RE: Suncadia Ph. 3 Div. 15 & 16 Boundary Line Adjustment (BL-19-00004)

MEMORANDUM

TO: Community Development Services
FROM: Taylor Gustafson, Environmental/Transportation Planner TG
DATE: April 23, 2019
SUBJECT: BL-19-00004 Suncadia Phase 3 Div 15 & 16 Public Works Review

JOB NO. 998-765-017-0002
DRAWN: C.A.F./R.F.G.
DATE: 2019-03-26
SHEET 1 OF 17

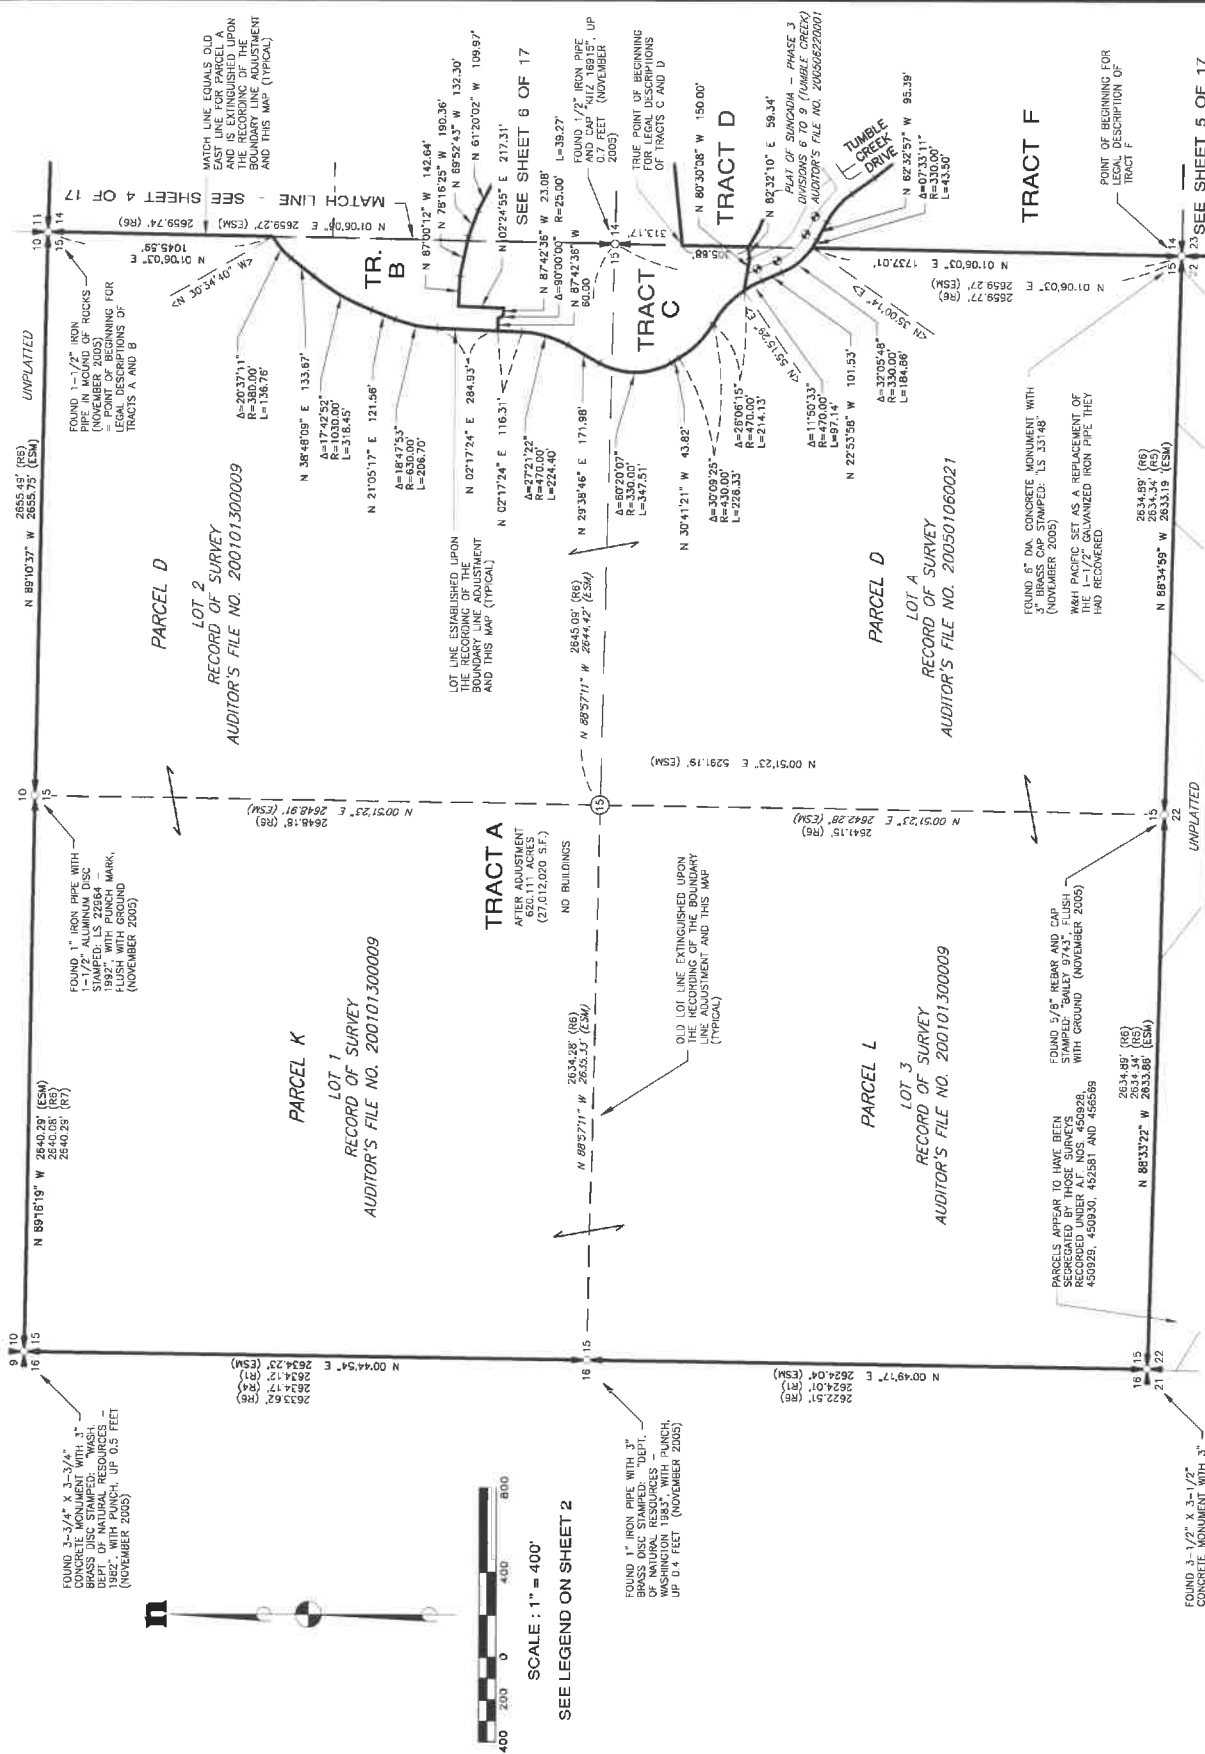
3. Note 1 about not setting corners, is typically not allowed.
I believe that the reason for not setting them is justified under RCW:58.09.020 for all lots under the ownership of New Suncadia, and under RCW:58.17.040(6) for Tract D.
If this is the intent, it should be noted.
4. The statement for Survey Instrumentation appears to have been cut off.

DB NO. 998-765-U17-0002	DATE: 2019-03-26
DRAWN: C.A.F./R.F.C.	SHEET 12 OF 17

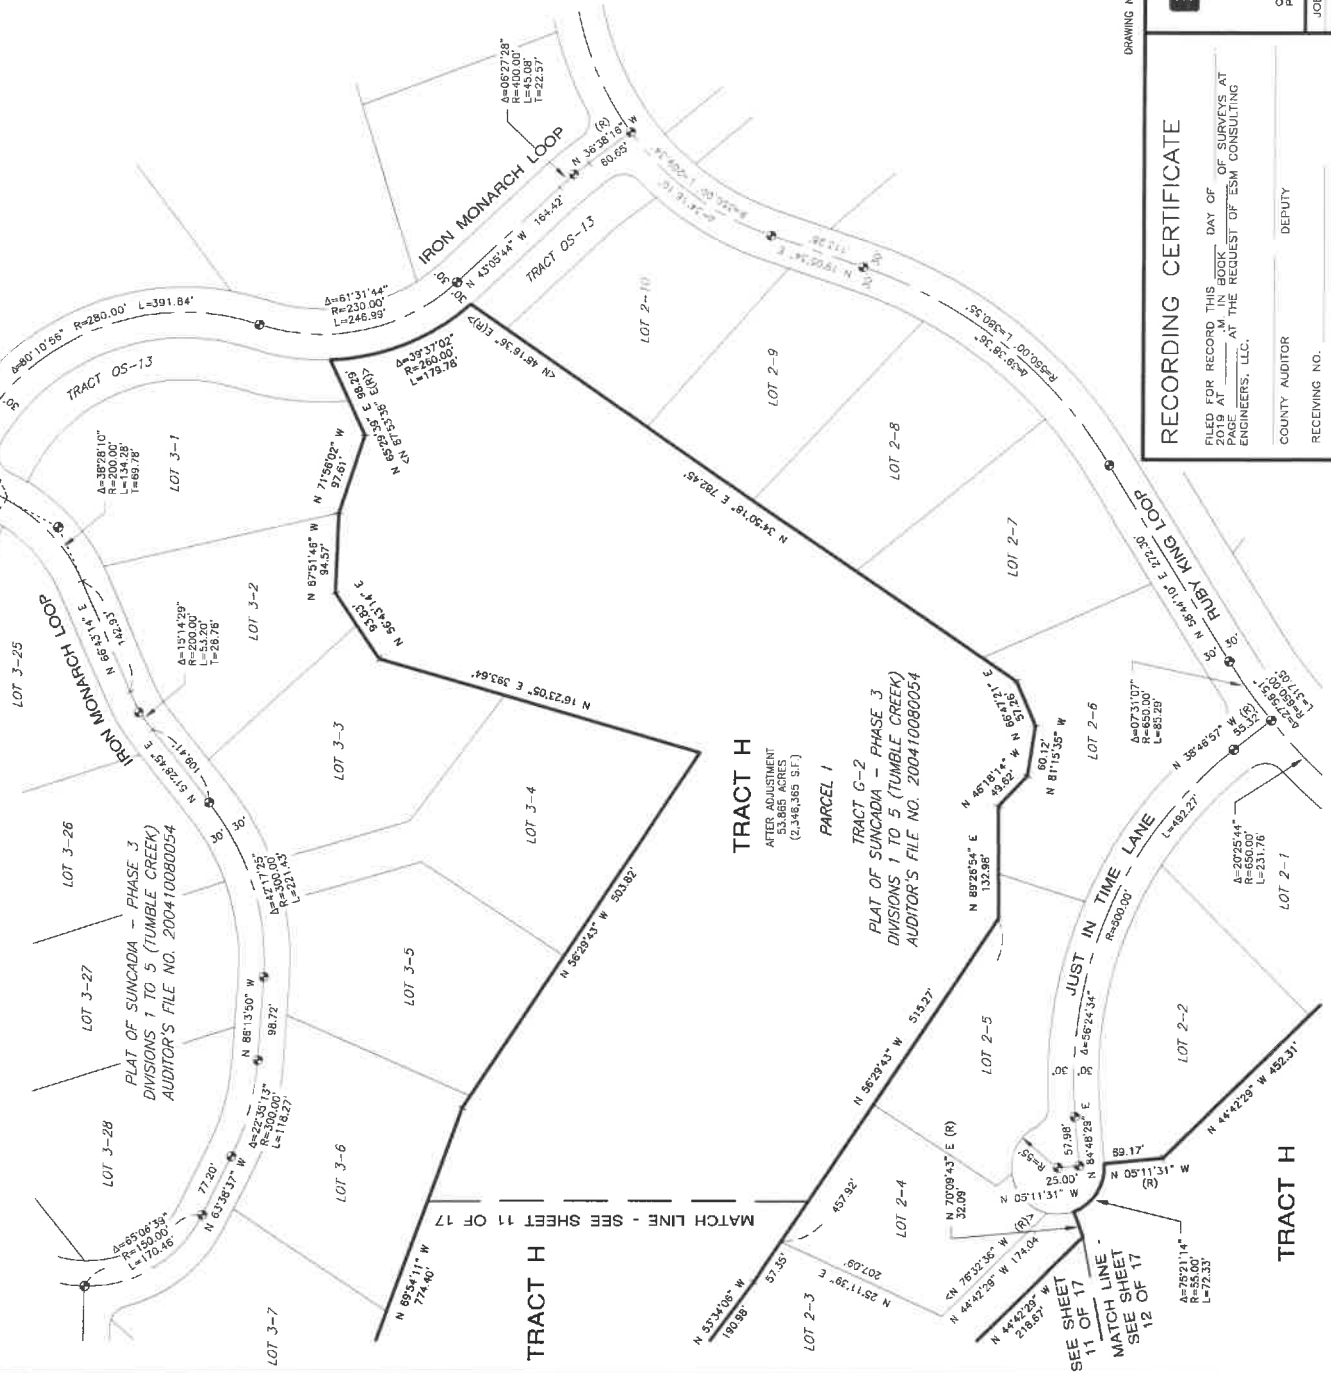
7. The line labeled as being 383.10 and the arc 290.36 in length along the north line of Tumble Creek drive do not match the closure report.
